An
Coimisiún
Pleanála

Inspector's Report

ACP-323433-25

Development	Section 146B request to alter the previously permitted replacement of existing biomass-fired boilers, biomass-fired thermal fluid heater and gas-fired thermal fluid heater at Medite's manufacturing plant (ABP-319013-24),
Location	Redmondstown, Clonmel, County Tipperary
Planning Authority	Tipperary County Council
Requester	Medite Europe DAC
Type of Application	Application under Section 146B of the Planning and Development Act, 2000 (as amended) to alter previously approved Strategic Infrastructure Development.
Date of Site Inspection	Not required
Inspector	Liam Bowe

Proposed Alterations Design
Development Area 1 & 2

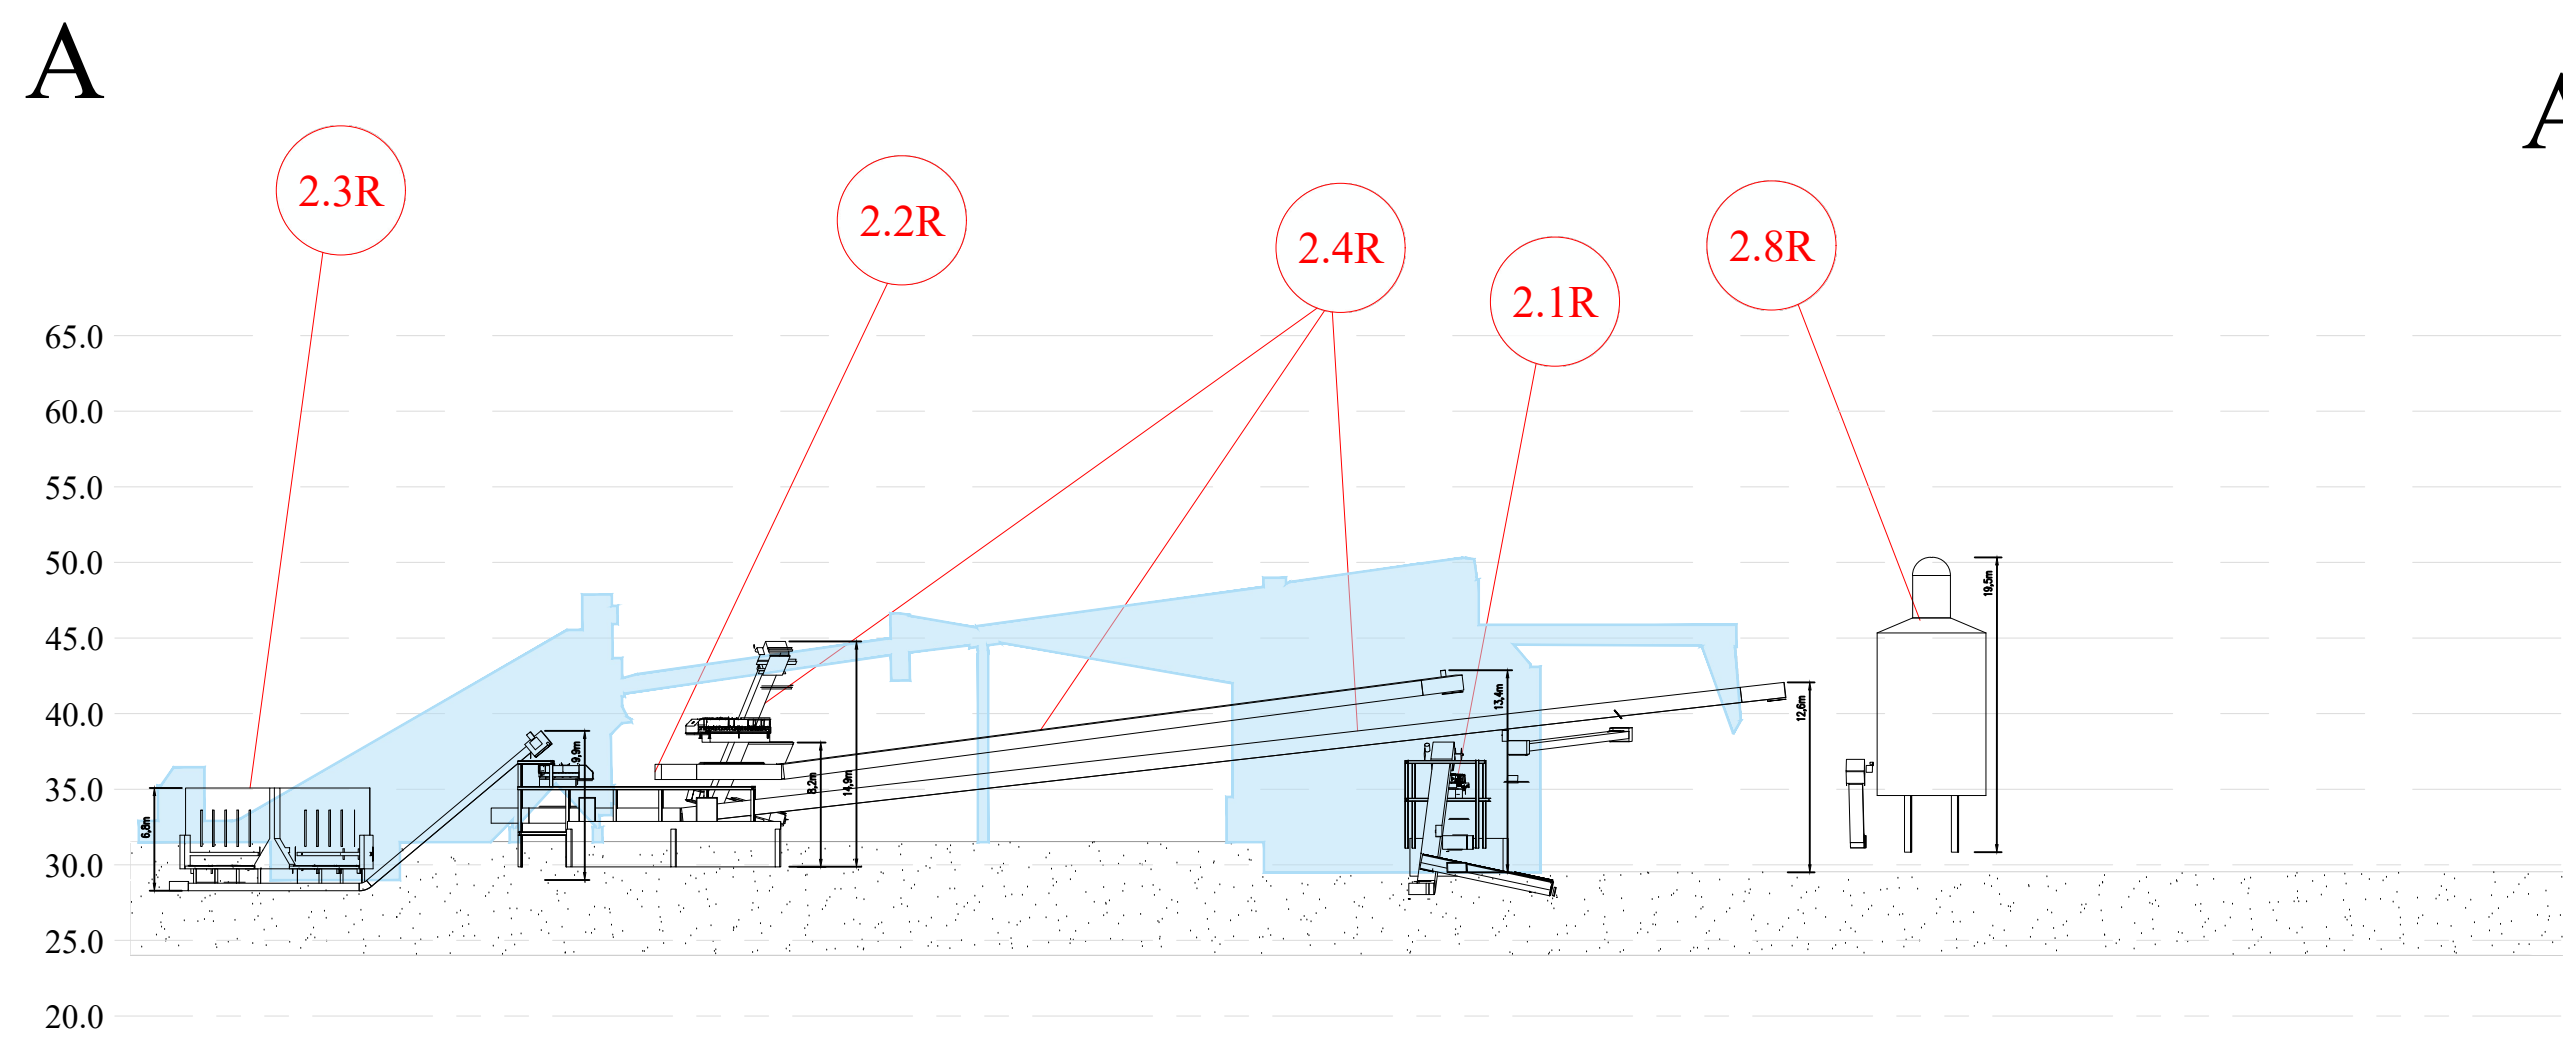
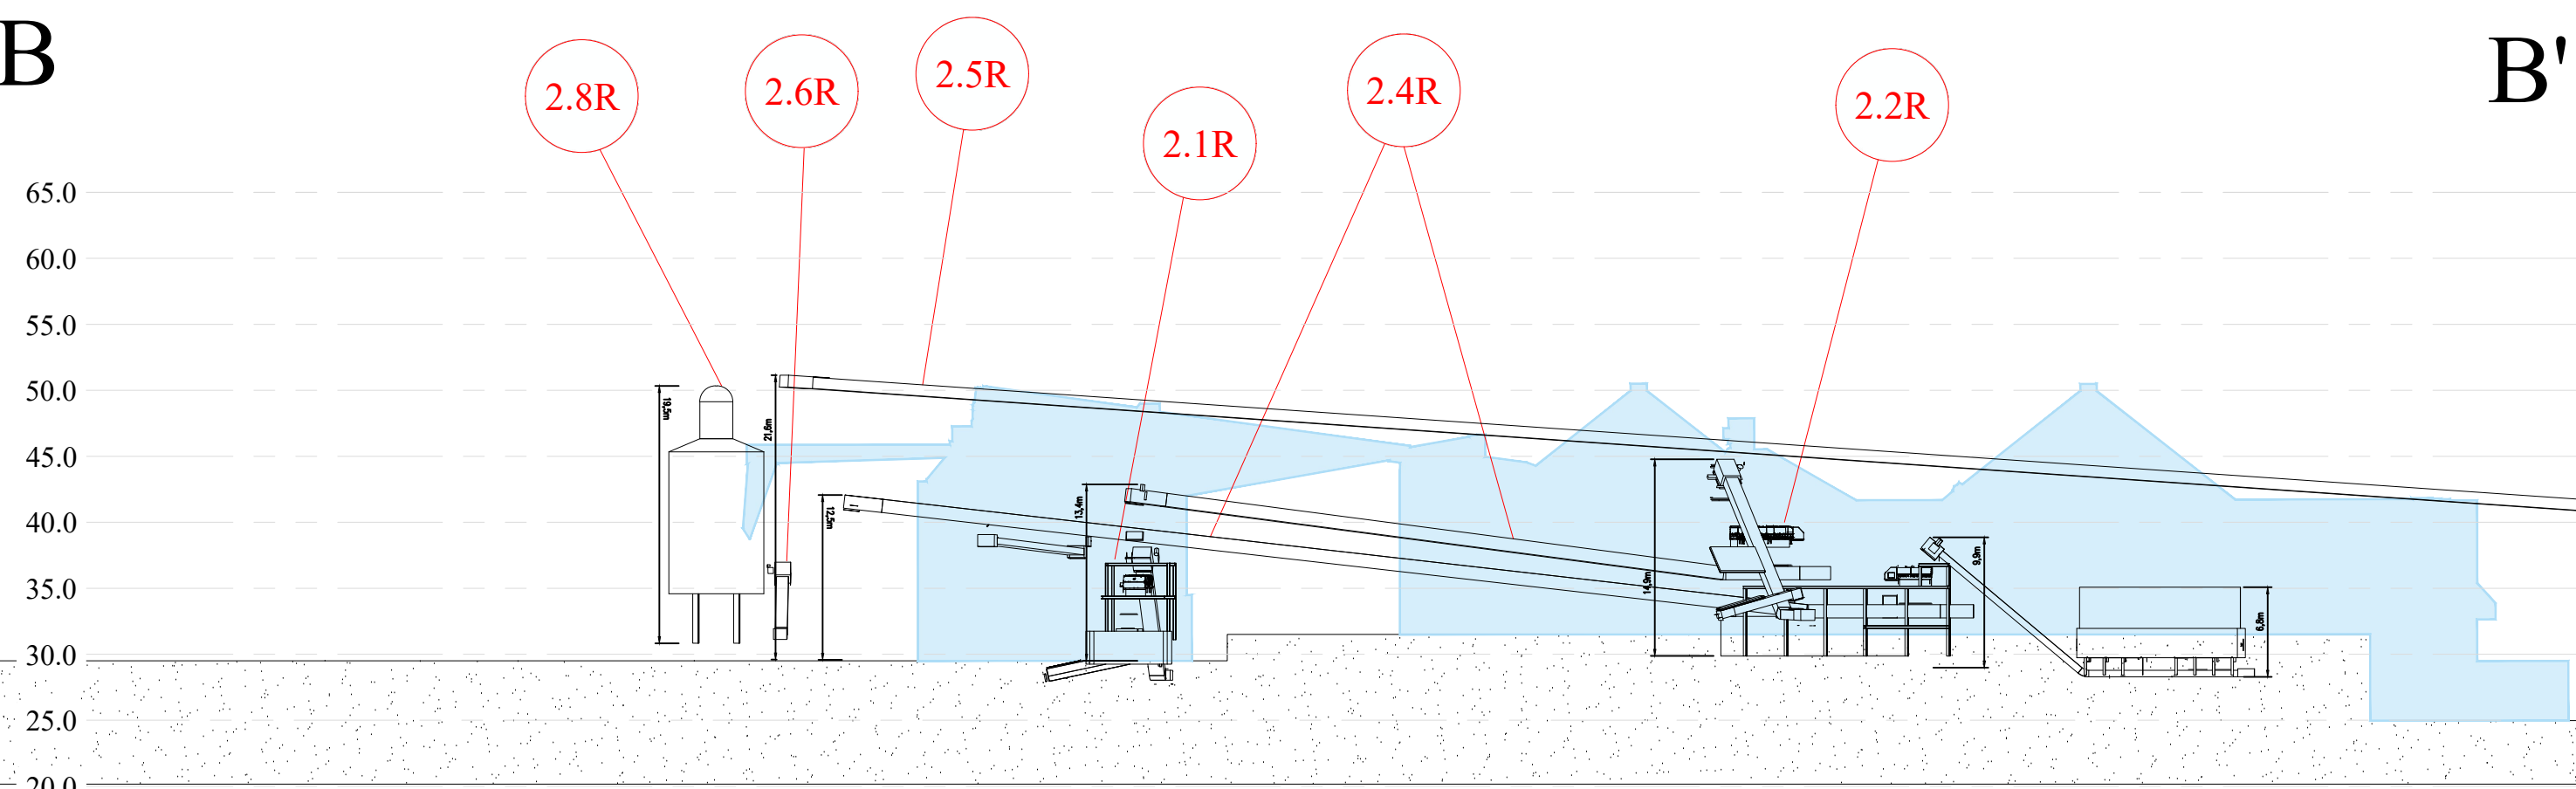
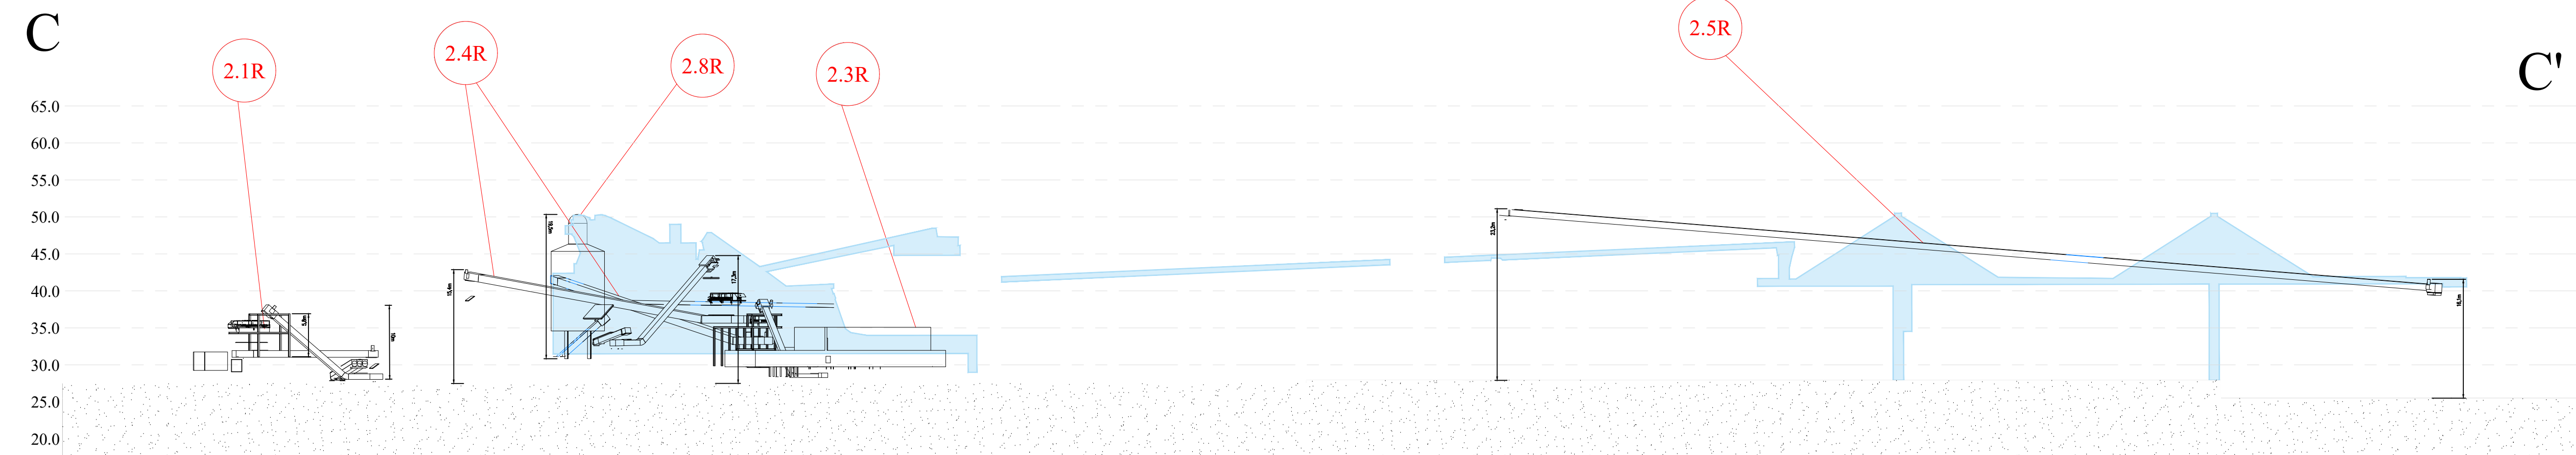
Table 1: Proposed alterations within Development Area 1

Item No.	Permitted Item	Proposed Item
2.1	Fuel Reception Unit 7.0m x 5.0m x 5.5mH Area = 35m ²	Fuel Reception Unit altered to 7.3m x 4.9m x 5.8mH Area = 35.77m ²
2.2	Fuel infeed hopper 3.0m x 6.2m x 5 m H Area = 18.6m ²	Fuel infeed hopper altered to 2.3m x 3.7m x 8.2mH Area = 8.5m ²
2.3	Walking Floor Infeed System 24m x 18.6m x 5.0m H	Walking Floor Infeed System altered to 27.3m x 12.2m x 6.8mH

Area = 446.4m ²	Area: 333.0m ²
2.4	Conveying Systems #1 Approx. 200m length Area = 520m ²	Conveying Systems #1 altered to 179.9m length Area: 207.4m ²
2.5	Conveying Systems #2 Line 1 Energy Plant Approx. 266m length Height to max of 22.5m Area = 295.9m ²	Conveying Systems #2 Line 1 Energy Plant altered to Approx. 170m length of conveying Height to max of 23.2m Area = 165.0m ²

2.6	Conveying Systems #2 Line 2 Energy Plant Approx 44m length Height to max of 20.9m Area = 77.5m ²	Conveying Systems #2 Line 2 Energy Plant altered to Approx 10m length Height to max of 11.0m Area: 11.0m ²

2.7	Pneumatic (Dry Fuel) Systems Pneumatic Transport Ducts #1 Length = 161.5m x Ø150mm #2 Length = 202.9m x Ø150mm Length = 364.4m	Pneumatic (Dry Fuel) Systems Pneumatic Transport Ducts #1 Length = 161.5m x Ø150mm #2 Length = 257.2 m x Ø150mm Length: 418.7m

2.8	Edge Trim Silo Ø = 5.6m H= 19.5m Area = 38.4m ²	Edge Trim Silo Ø = 7.2m H= 19.5m Area = 51.7m ²
